From:
Sent: 09 July 2025 17:09
To: DC Admin
Subject: Planning 2025/62/91168/E

2025/62/91168/E Wilton Mills 586 Bradford Road, Batley, WF17 8LP

Demolition of existing garage and erection of MOT bay/service bay/storage area (within a conservation area)

PROPOSED SOUTH EAST ELEVATION, SCALE 1:100

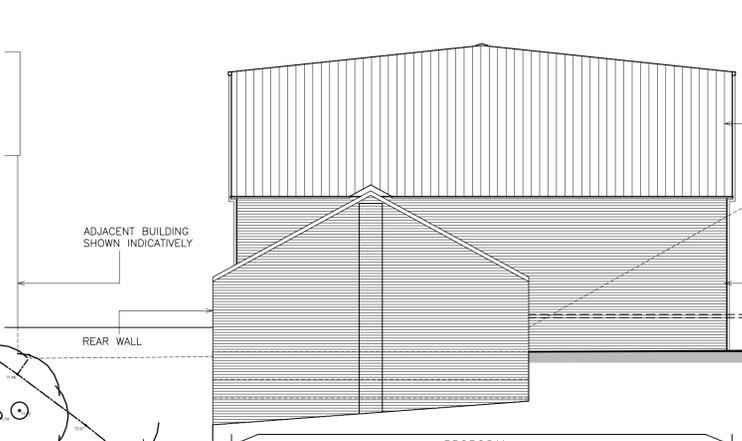
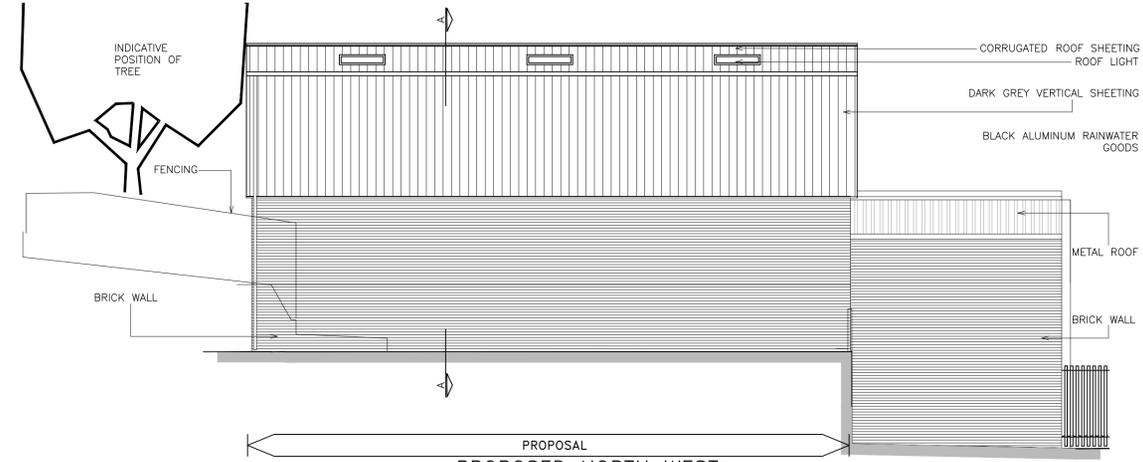
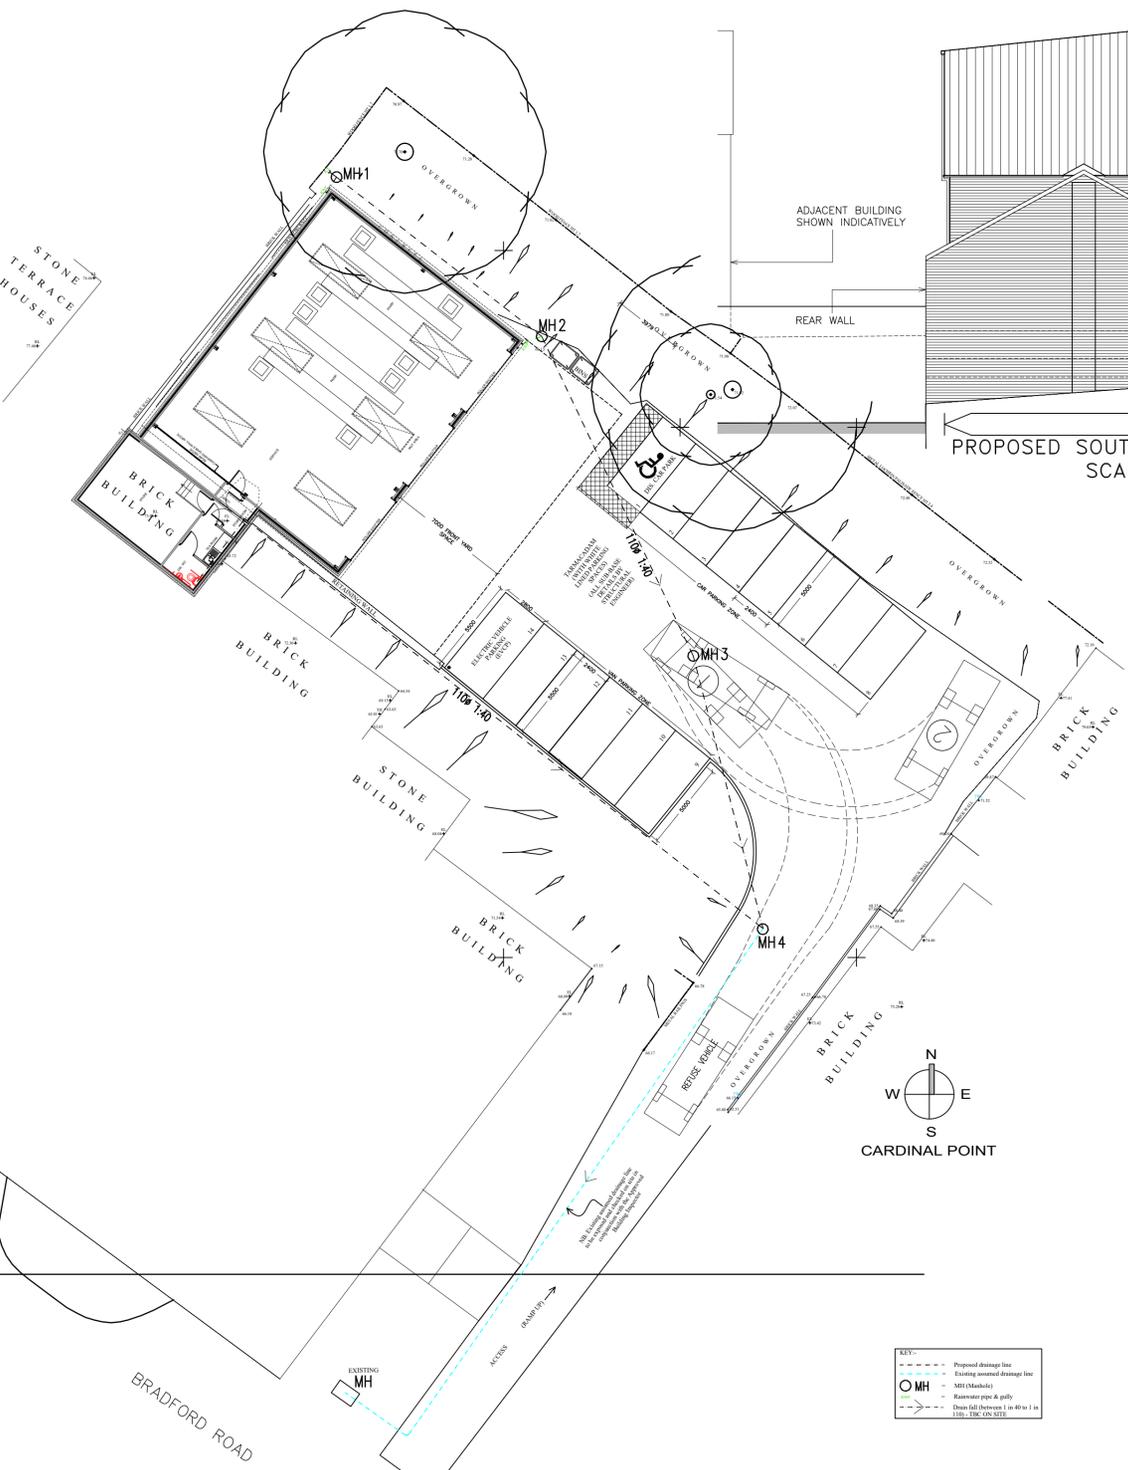
1 The height of the structure is more than was approved on previous planning. It totally overwhelms the area. Photo 1 show the rearview that backs on to the back-to-back terrace houses at the bottom of Carlinghow lane. The rear houses would suffer the worst with overshadowing and loss of natural light resulting in light deprivation. In addition, the detached house On the corner of Carlinghow Hill and Chinewood Avenue would suffer over shadowing and light deprivation. Photo 6 shows the existing building roof line to the left of the construction. On the approved planning the roof height was slightly above this level. Photo 1 and 3 also show the buildings size from Bradford Road and how it overshadows the area. As you can see it is not hidden as stated in the application Heritage-Design and Access Statement, it is full on, look at me the building that was built without planning permission!

2 From the photos supplied you can see the type of materials used in this area of Cross bank conservation area, metal sheeting is totally inappropriate, a combination of stone, brick, slate and rendering should be used. If rendering is used the bare block work should be enforced to be finished to a satisfactory standard. The Cross Bank Conservation area was set up specifically to help preserve the area distinct character for generations to come. At the time the Conservation area was set up Stan Driver, principal planning officer for conservation and design said "Planning applications would need deeper scrutiny in some areas, Councillors will have to think harder, as well as applicants." Photo 6 shows an example of this with Harry's takeaway being built from stone. The applicants state in the Heritage-Design and Access Statement that "The result will be a purpose built unit Typical of many similar units in the area. The site is unseen from the main road and largely hidden from site" is untrue and incorrect. The photos show that it is clearly seen from Bradford Road and Carlinghow Hill. The site is also overlooked By Chinewood avenue with upper floors having a bird's eye view. I strongly disagree with the adjective Typical and many similar units as again this is untrue. The new B an M store on Mayman Lane was even stone fronted and that wasn't planted in the middle of housing (Housing to 3 sides)

4 This building will be like a blot on the landscape surrounded by historic buildings, The tram shed, National school 521 Bradford Road(listed). The photos attached show the type of building in the immediate area, it will have a negative impact on the local character, within a conservation area. The building does not align with buildings that surround it, it is not hidden from view.
